Re: Section 73 Variation of condition application to planning consent SDNP/22/05710/FUL dated 18th May 2023– Erection of 20 pre-fabricated glamping pods and associated footpaths, retrospective alterations to previously consented raised timber decking adjacent to driving range with addition of pergola and associated alterations, and erection of pergolas over clubhouse rear patio at: Blacknest Golf & Country Club, Frith End Road, Blacknest, GU34 4QL

Please find enclosed a section 73 Variation of Condition application for minor material amendments to planning consent SDNP/22/05710/FUL.

PROPOSED SITE PLAN + PHASING OF POD & PATHS CONSTRUCTION - Scale 1:200 @ A0

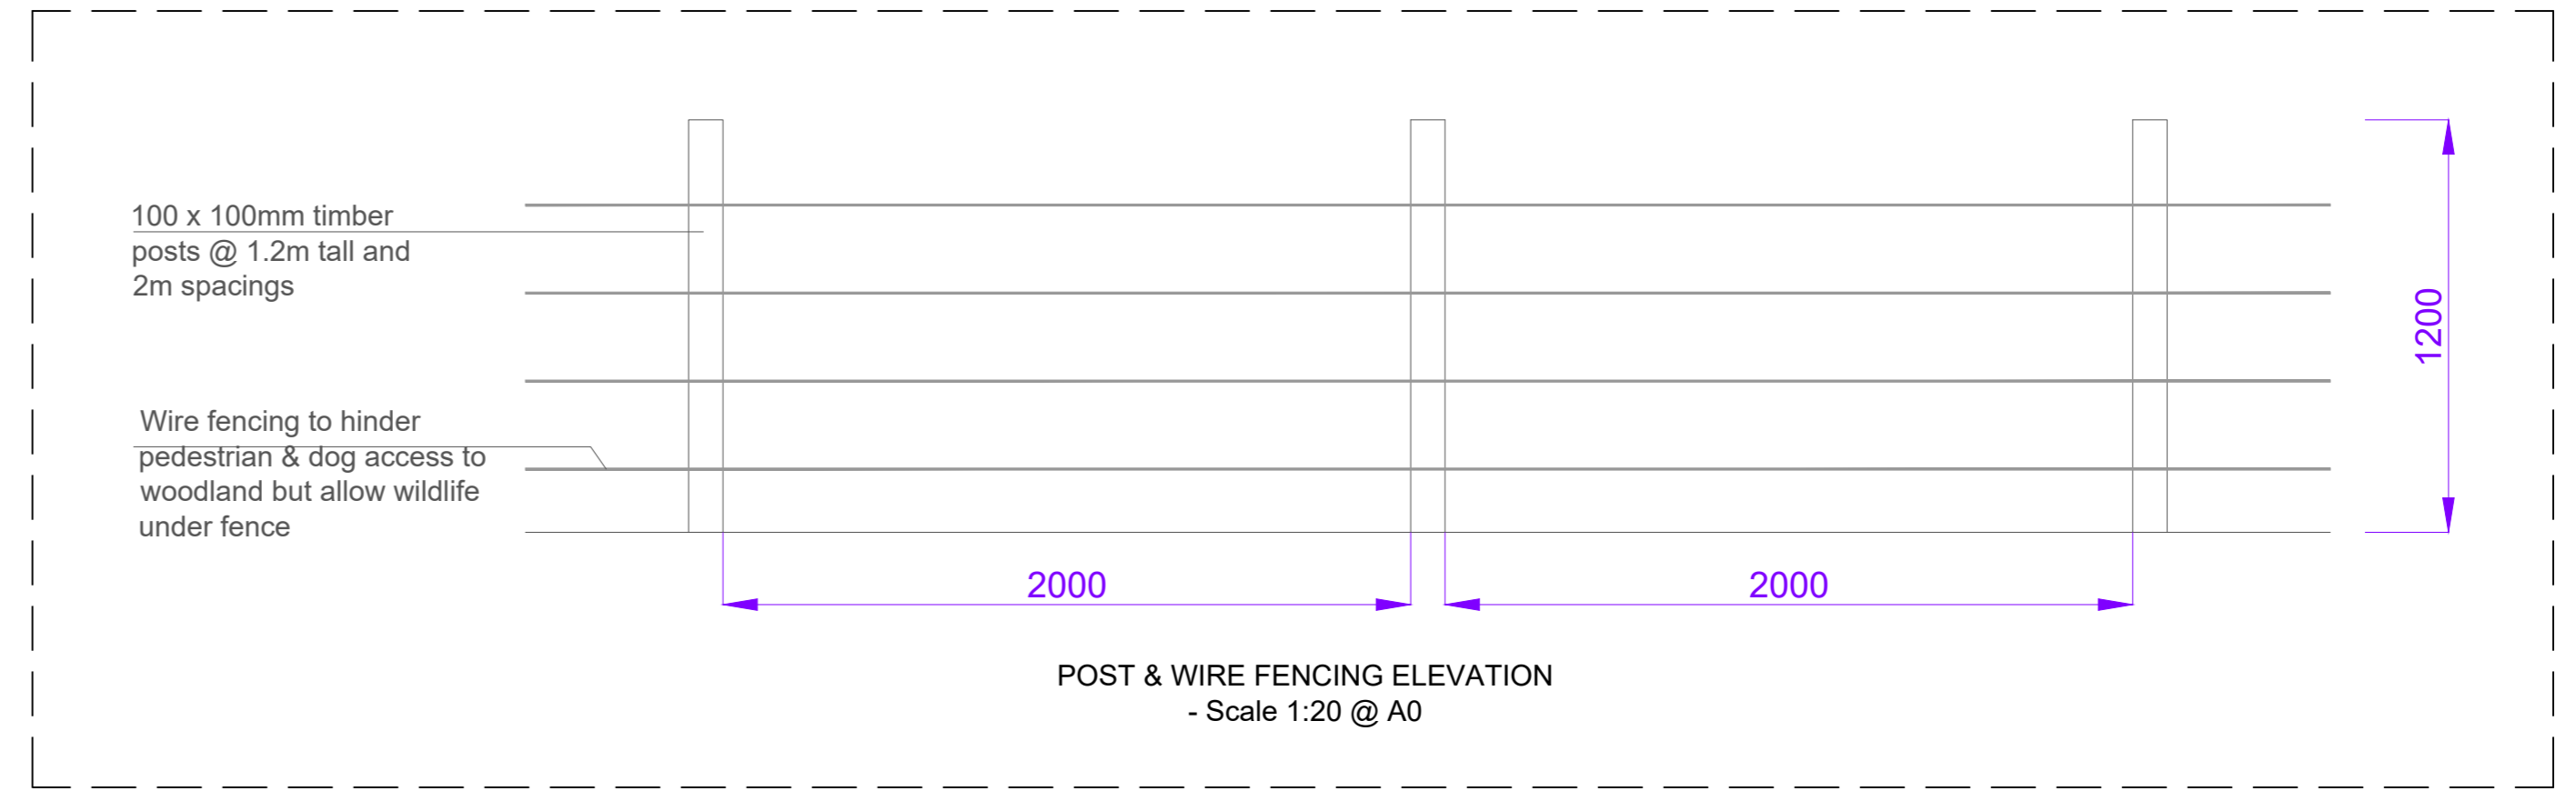
- Replacing the cabins with an alternative cabin manufacturer in similar locations.
- And, insignificant minor alterations to the associated paths and landscaping layout adjacent to the cabins to accommodate the new cabin types due to the positioning of their front doors.

- Request to vary the condition wording to take consideration of the phasing of installation of the cabins, which is proposed in 3 phases, to allow the install of phases 1 and 2 without needing to fully implement all the proposed landscaping for the whole scheme. Request for a phased install of the landscaping requirements, with preferably the landscaping to be completed prior to occupation of phase 3.

DRAWING TITLE  
PROPOSED NOKKEN POD - 03

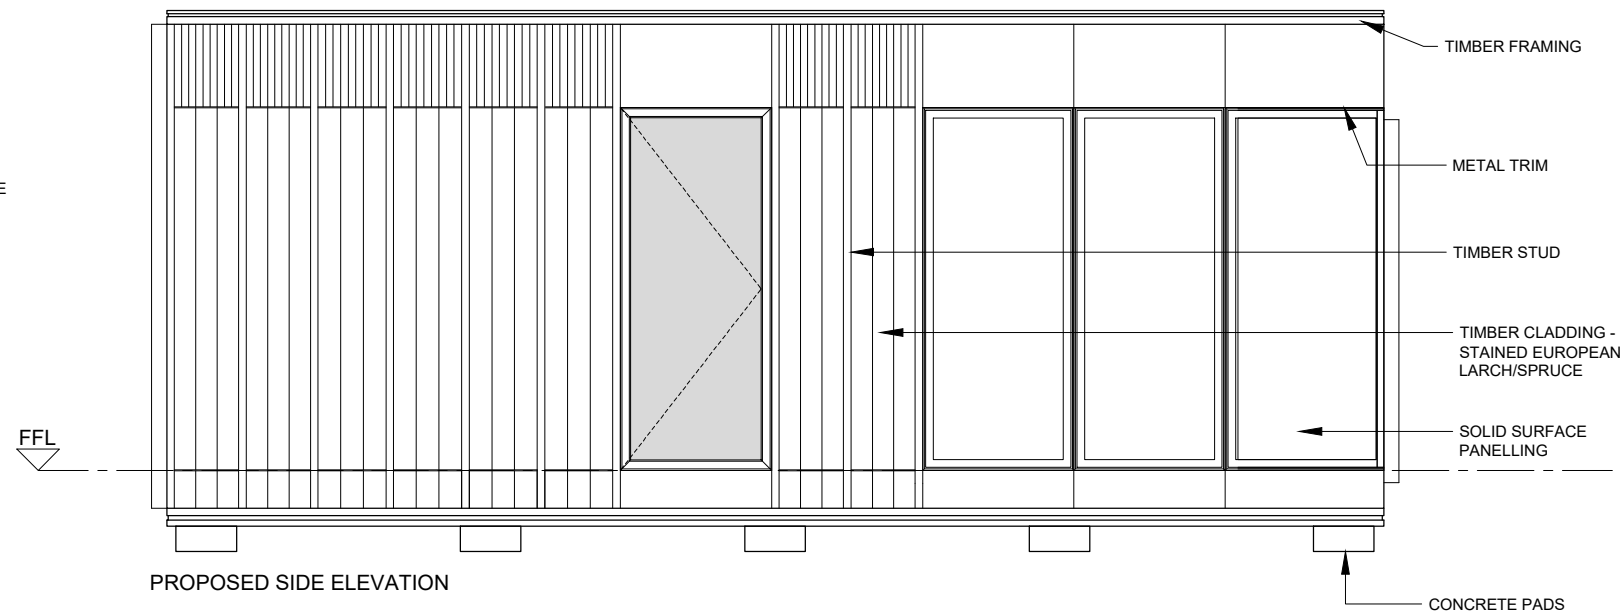
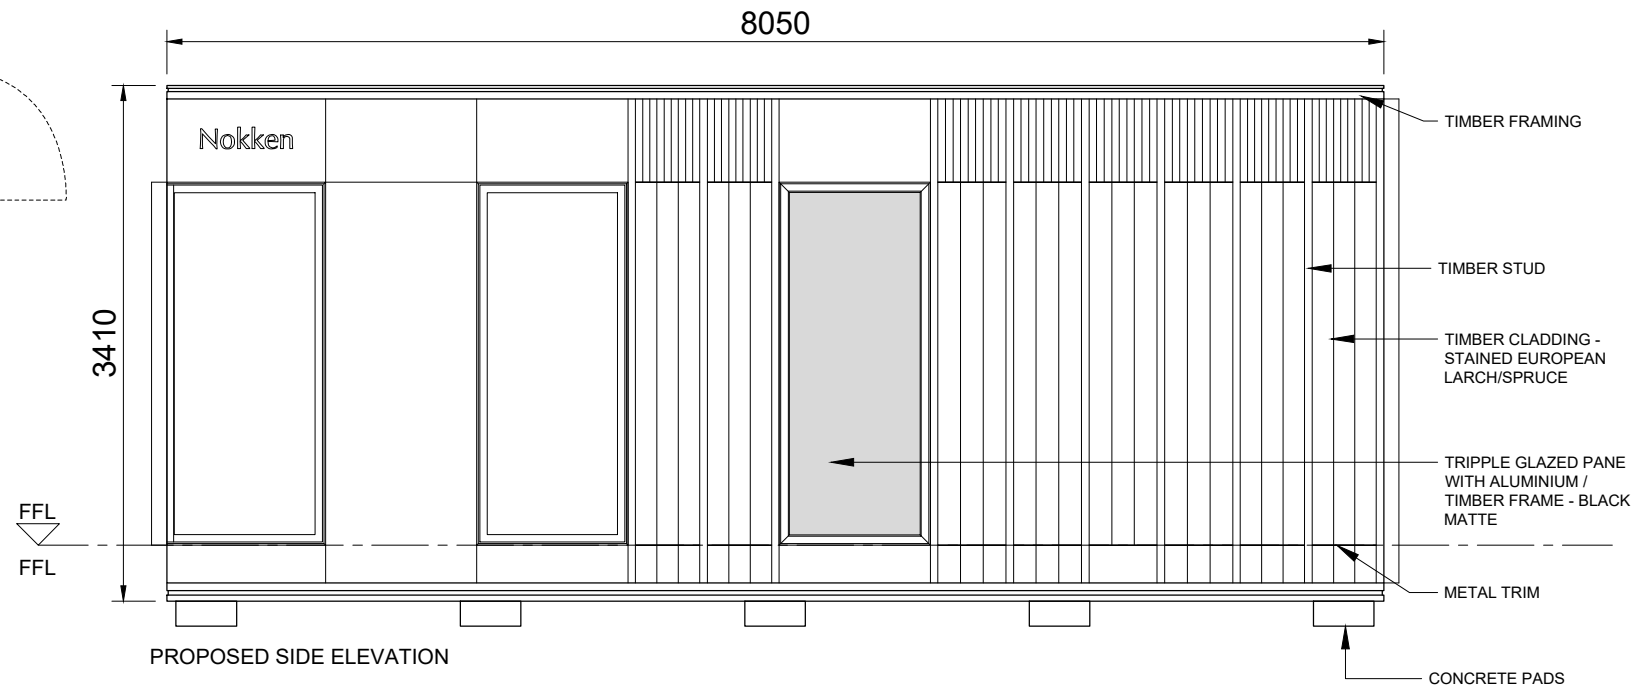
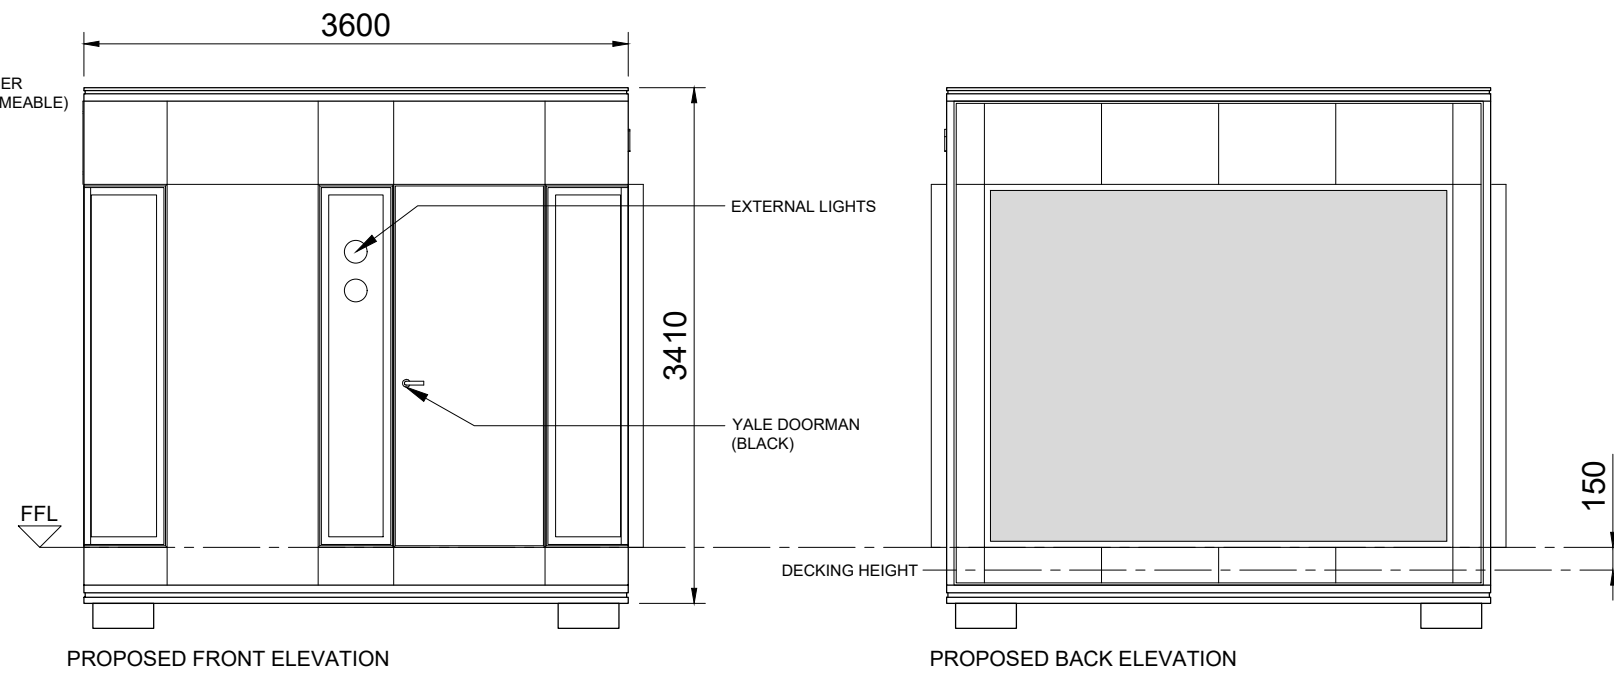
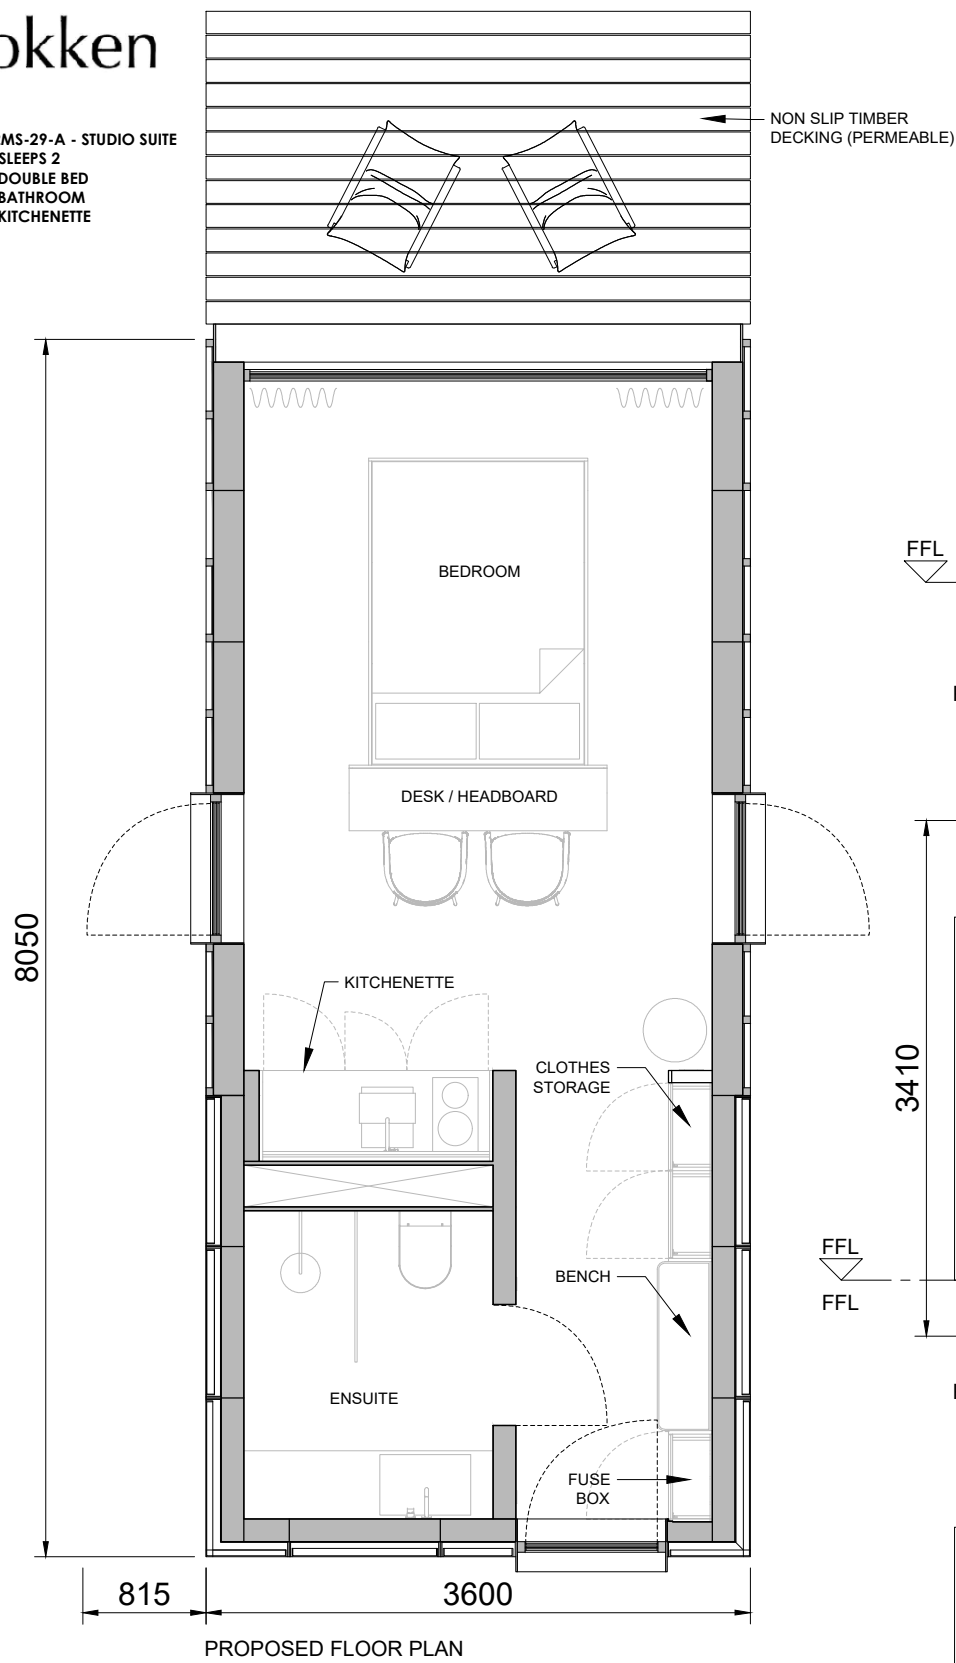
- This condition is to be amended to replace the proposed drawings and documentation to allow use of a different manufacturer and type of cabin, with associated alterations to the paths, landscaping etc to accommodate the minor changes in size and positioning of the cabins.
